WA/73/18/HH

Front porch & enclosure for wood burner. This application affects the character & appearance of the Walberton Village Conservation Area.

2 Parsons Walk Walberton BN18 0PA

PROPOSED ELEVATIONS

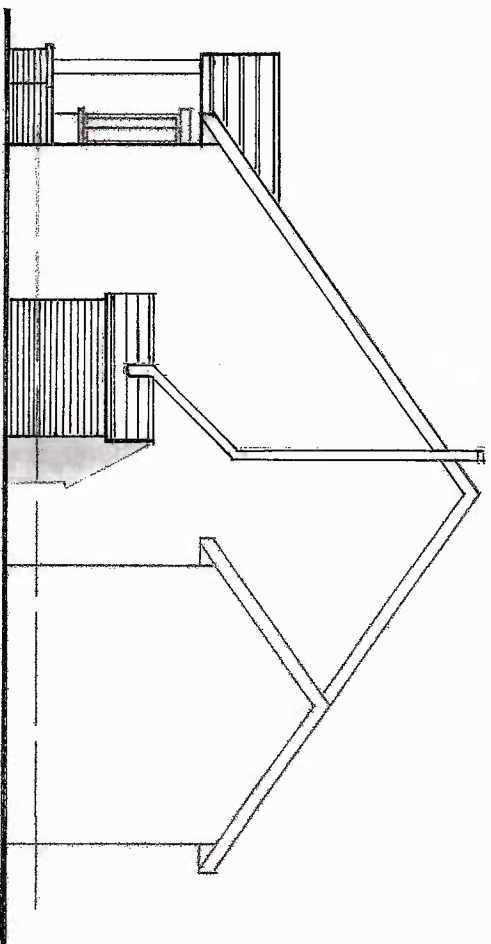
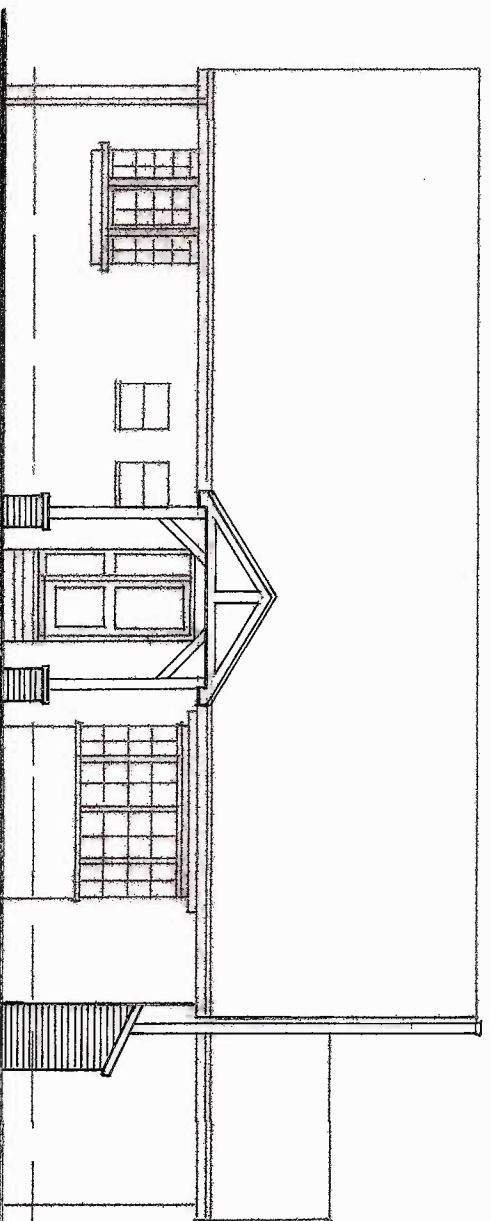
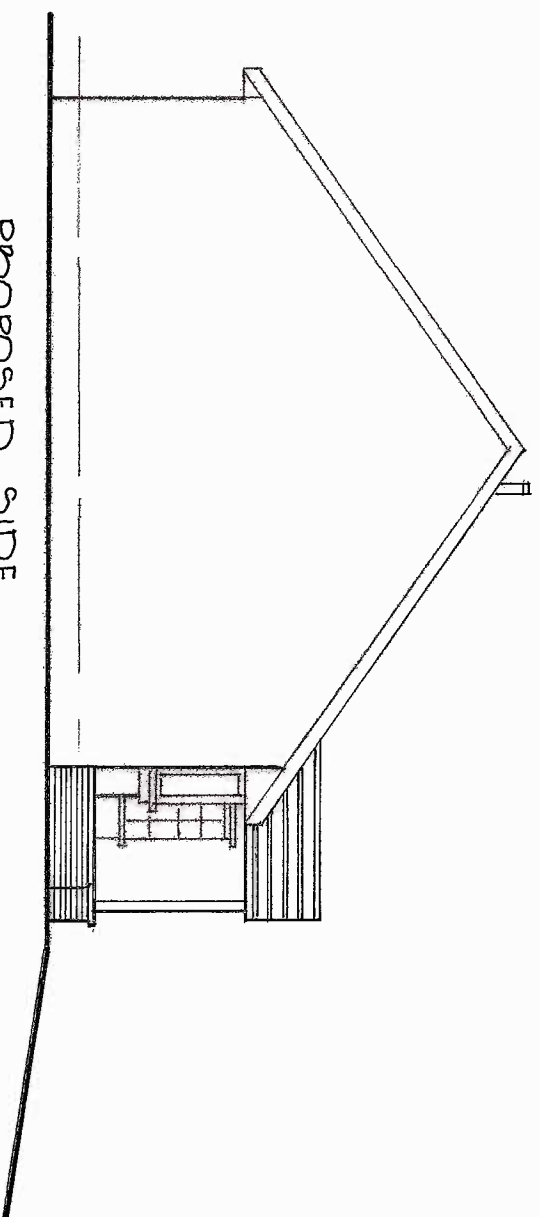
*Please obtain of materials in the extension and
details of the chimney and its crown to be submitted*
